From: Sarah Burrow <Sarah.Burrow@arun.gov.uk>
Sent: 21 January 2022 08:50
To: Planning.Responses <Planning.Responses@arun.gov.uk>
Subject: RE: Planning Consultation on: FG/184/21/PL

Engineers Comments Regarding Surface Water Drainage

Application No: FG/184/21/PL
Registered: 15th October 2021
Site Address: 1 Greenways Crescent Ferring BN12 5EF
Grid Reference: 509577 102444
Category: Plan Applicat'n
Description of Works: Erection of replacement dwelling and garage

Consulting Civil Engineers					
CLIENT		MR & MRS C NEWELL			
ARCHITECT		PHILIPS SURVEYORS			
JOB TITLE		1 GREENWAYS CRESCENT FERRING			
DRAWING TITLE		DRAINAGE STRATEGY			
DRAWN	LH	ENGINEER	C SLADE	CHECKED	CS
DATE	MAY 2021	SCALE @ A1	1:100		
JOB No.	C1692	STATUS	P	DRAWING No.	100
		REV.	P1

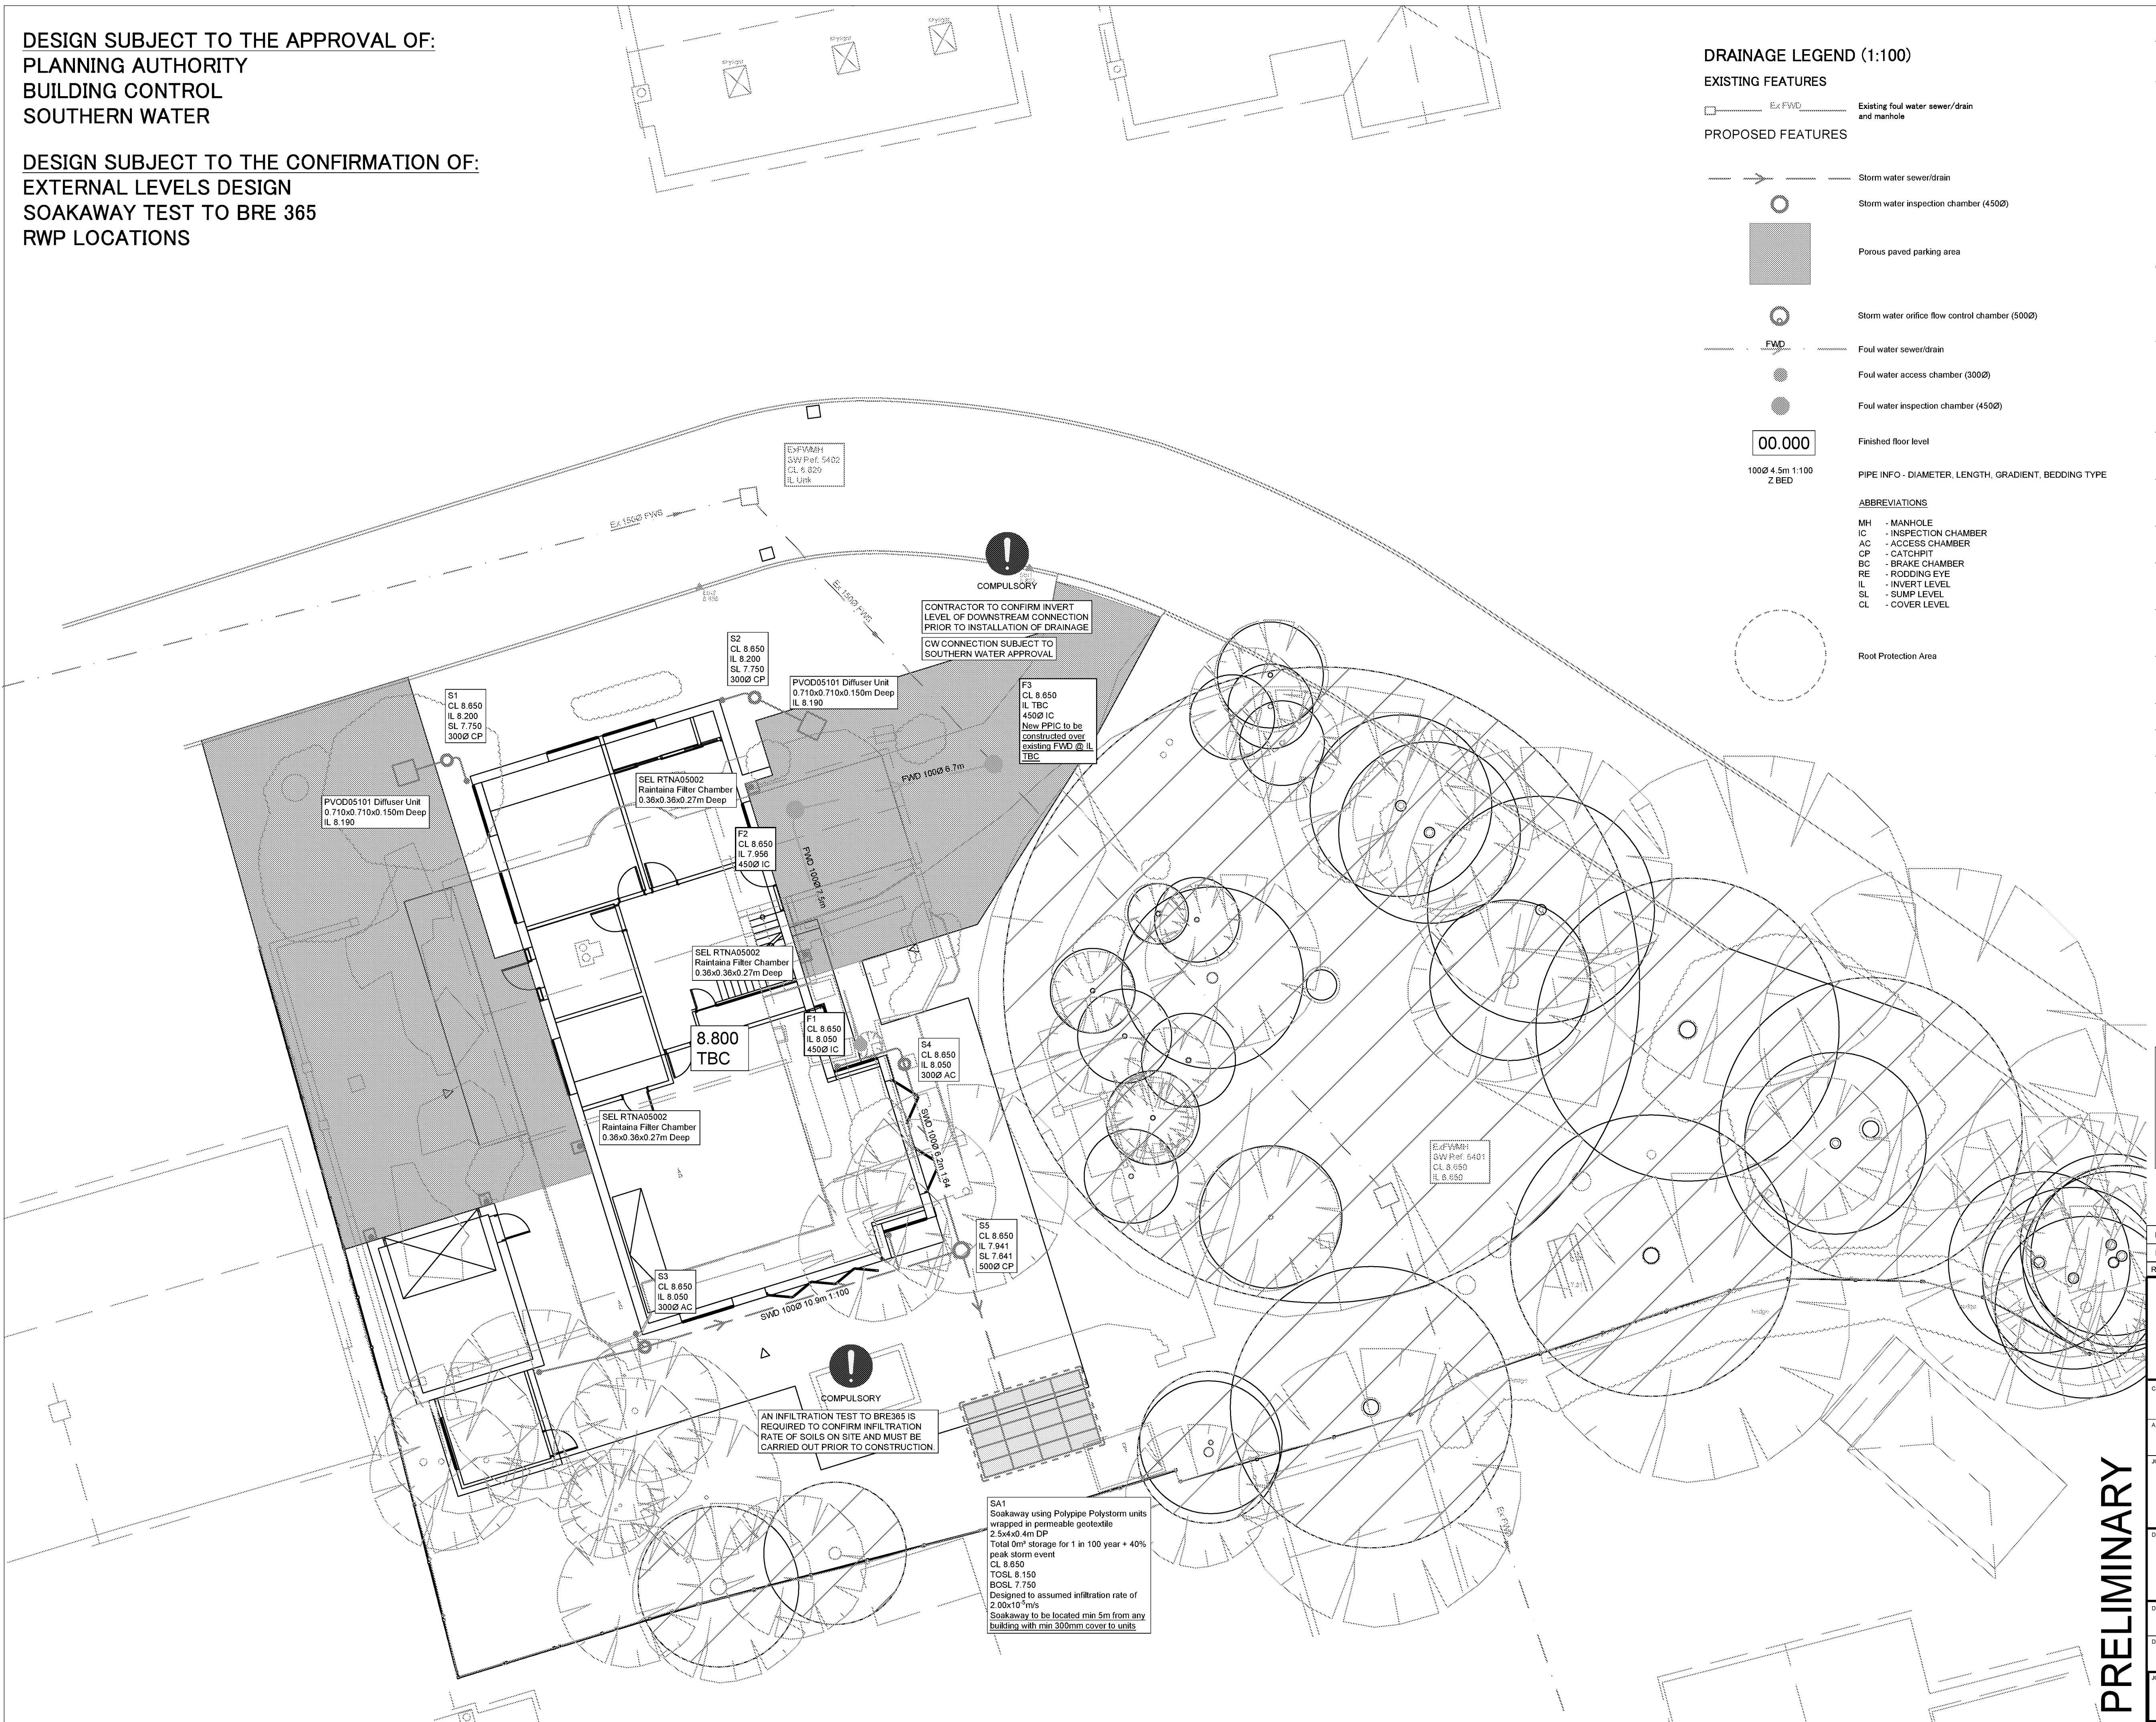
The Building Inspector should be aware that the drainage design that has been supplied is based on an assumed infiltration rate with no on site infiltration testing completed.
